Appeal Decision

Decision date: 27th May 2022

Appeal Ref: APP/R5510/D/22/3294217

19 Highfield Drive, Ickenham UB10 8AW

SCALE	1:100, 1:500 & 1:1250	@ A1	STATUS	PA
DATE	23/04/2021		CHECKED	HM
JOB.NO.	19-21-01		DRAWN	SG
DWG.NO.	PA-01		REVISION	A

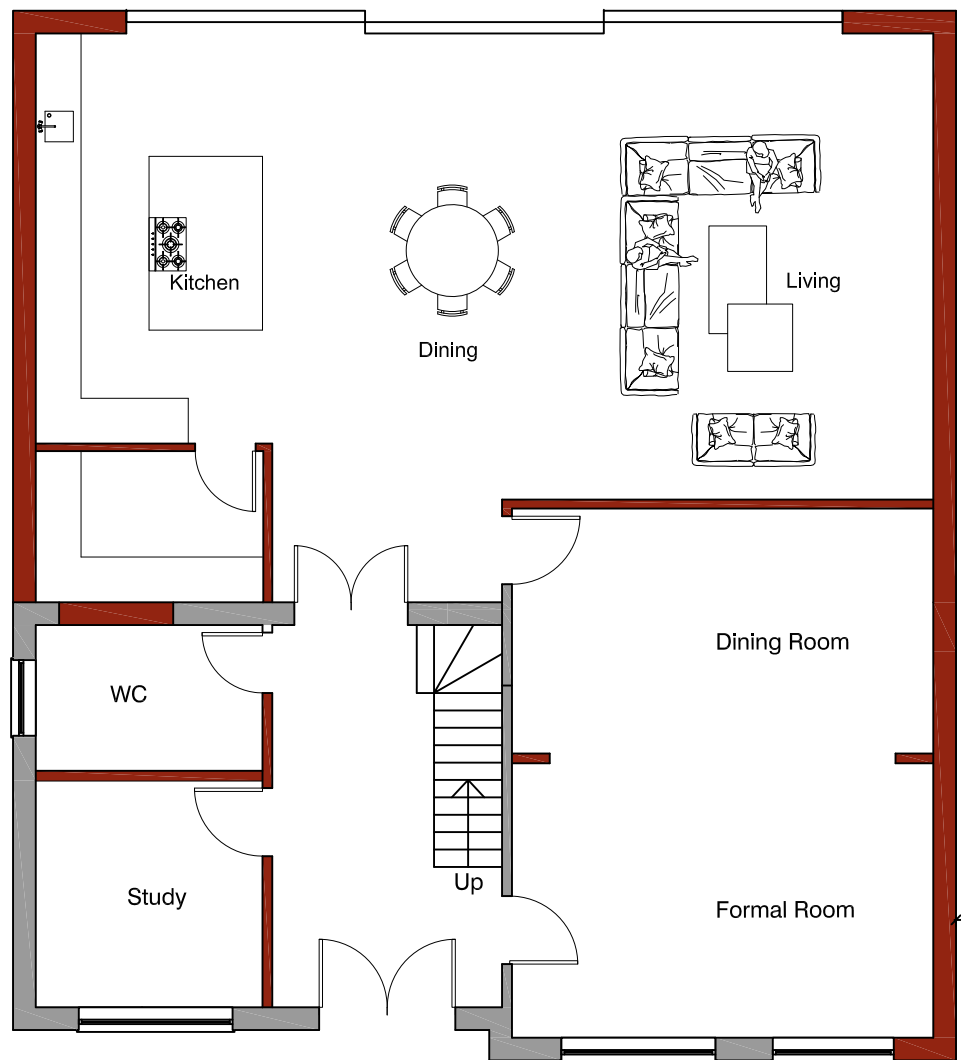
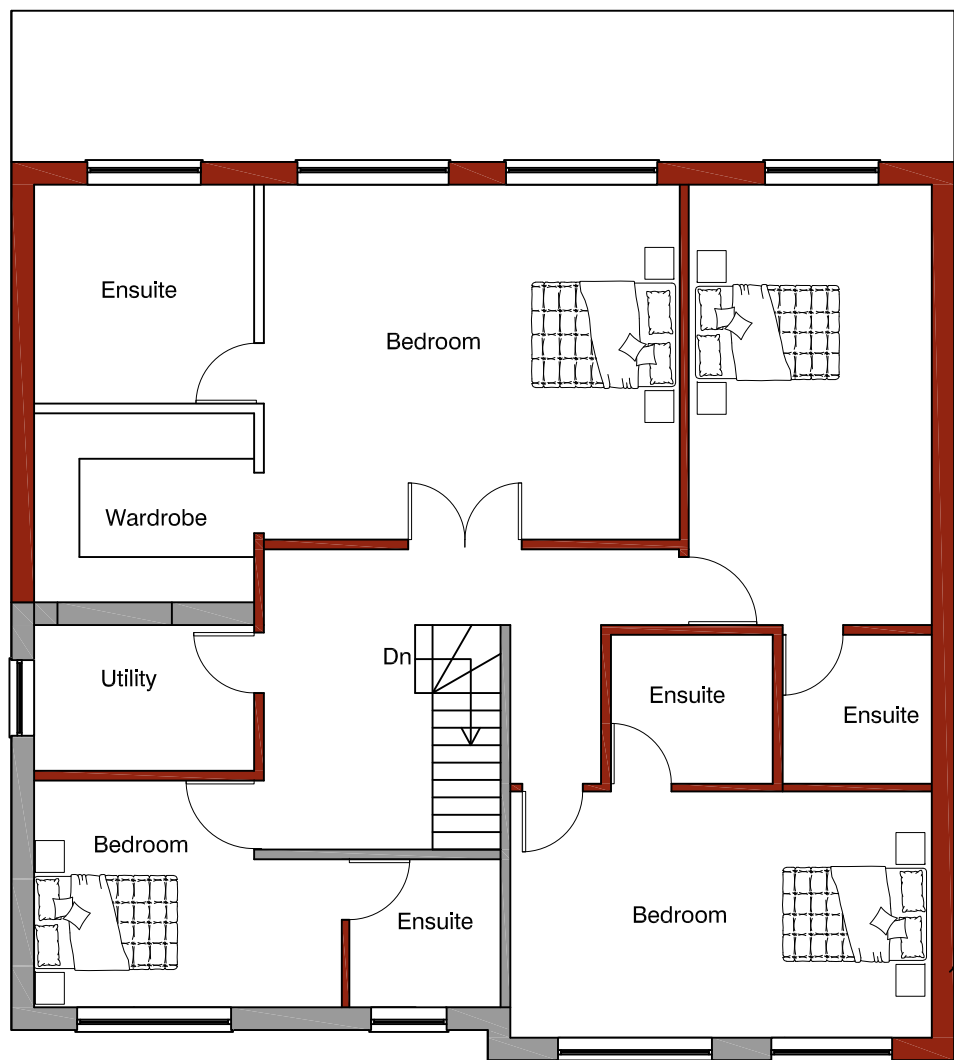
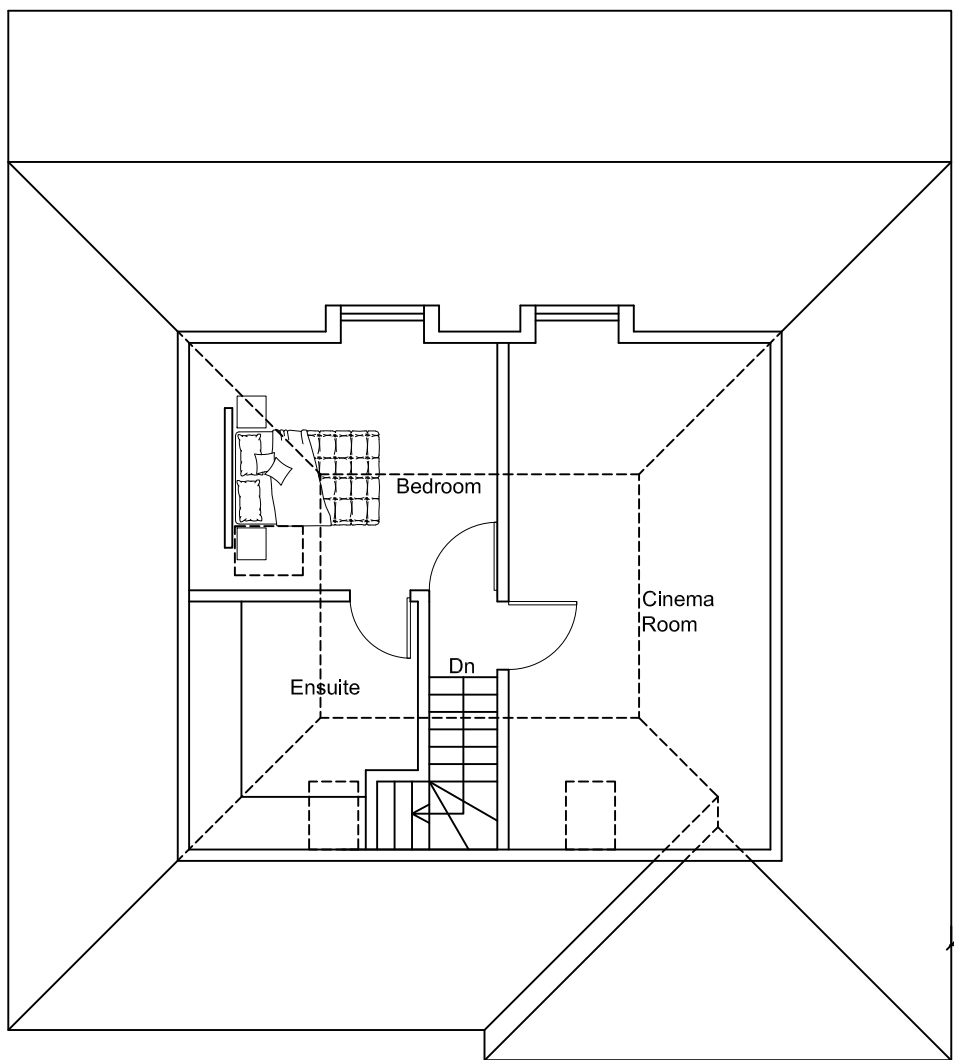
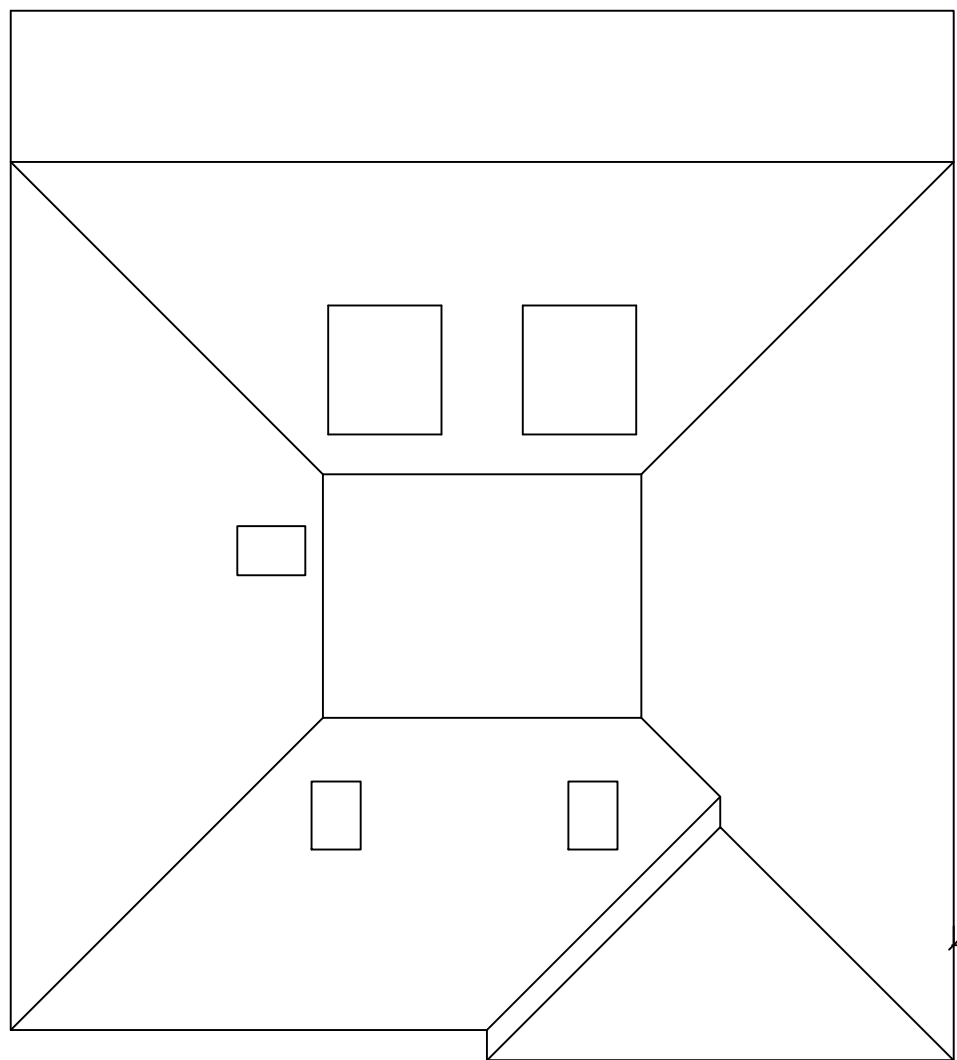
16. The Council states that the proposed part single, part two storey side/rear extension (the proposed extension) would project beyond the building line of No 21 by approximately 2.4m at first floor level and by approximately 4.4m at ground floor level.

17. The height and depth of the proposed extension would be sizeable and positioned in fairly close proximity to No 21. Nonetheless, given its 1m separation from No 21 and even greater separation from the adjacent windows, it would not appear as an unduly dominant and overbearing feature, or give rise to an uncomfortable sense of enclosure, when viewed from the pertinent habitable rooms of No 21.

21. I have had regard to the representations made by the occupants of No 21 which query the presence of a 1m gap between the proposed part single, part two storey side/rear extension and the boundary of their property. Drawing Refs: PA-01 - Proposed Street View and PA-01 Rev A - Proposed Floor Plans and Elevations confirm the presence of a 1m separation. On this basis and due to the additional reasons set out above, I consider that the proposed development would not materially harm their living conditions.

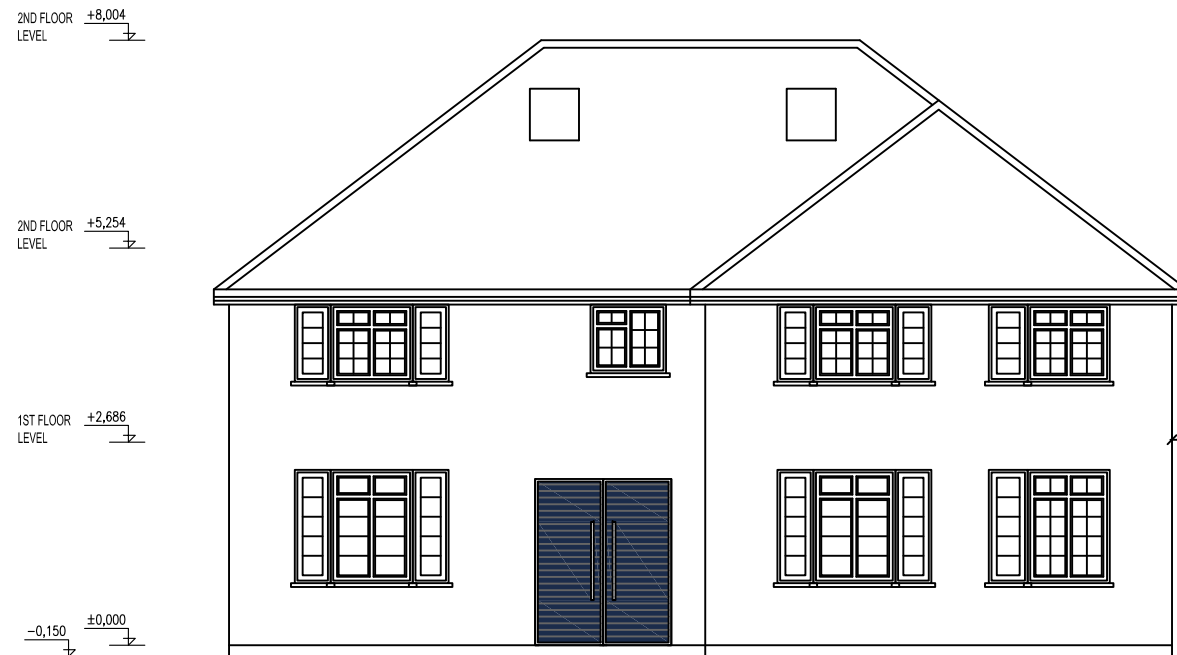
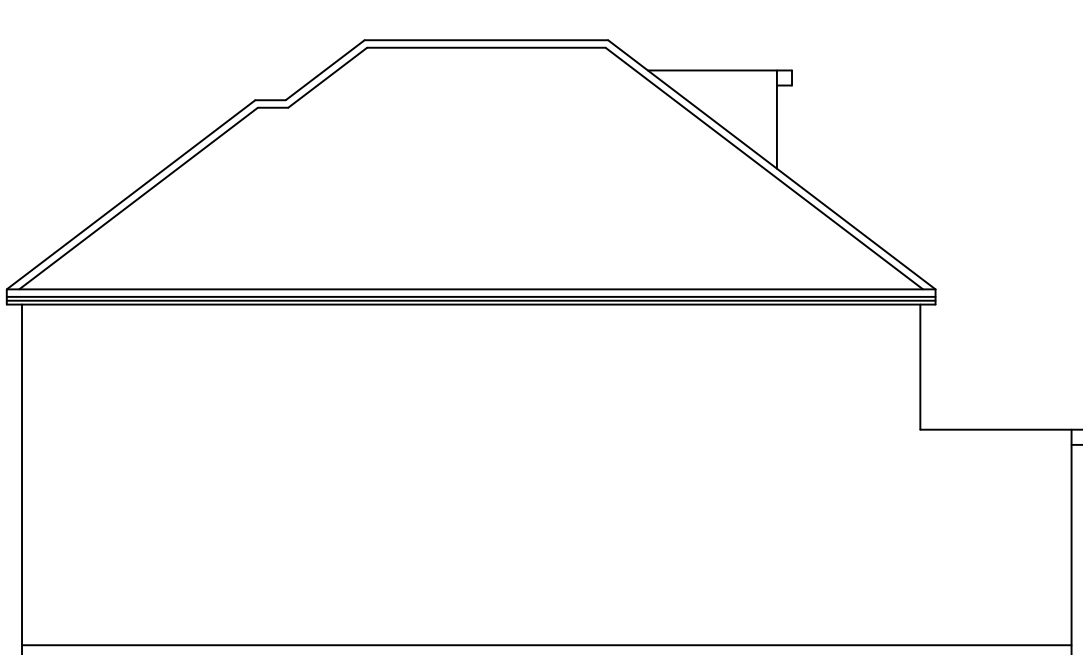
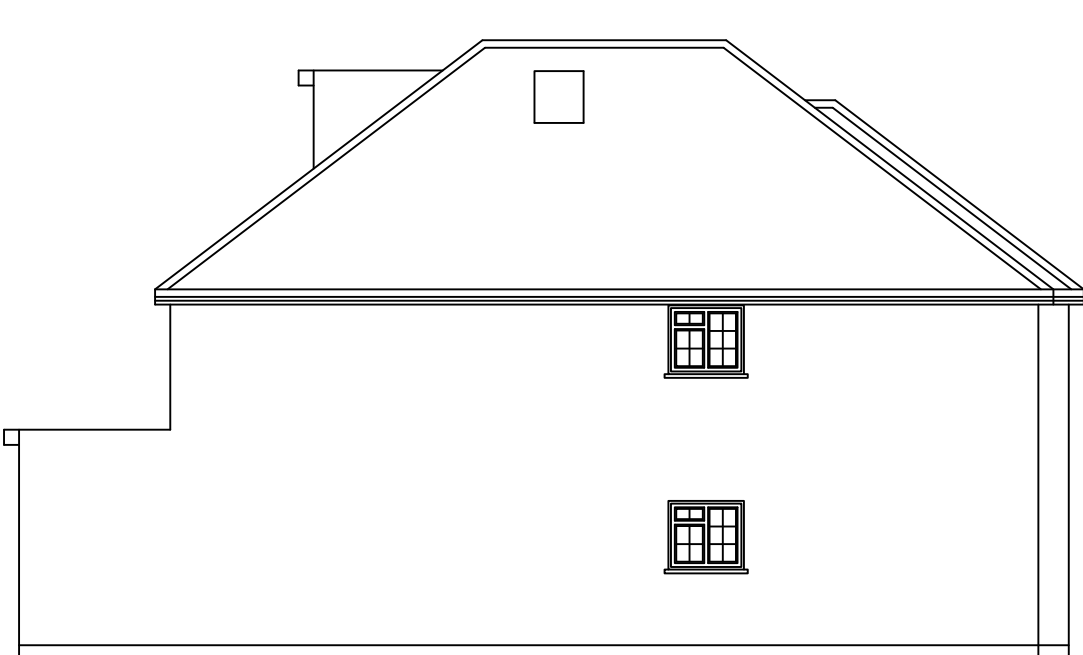
9. The proposed development would significantly increase the footprint and overall massing of No 19. Nevertheless, the comprehensive modification of the building along with the use of matching materials would mean that the additions, including the front gabled element, would not appear dominant,

10. Similarly, even though the proposal would increase the bulk and alter the profile of No 19's roof, given the size of the remodelled dwelling, it would not appear unduly disproportionate or top-heavy. Additionally, the diversity of roof forms and shapes on other buildings in the locale would mean that it would not be discordant in the street scene.
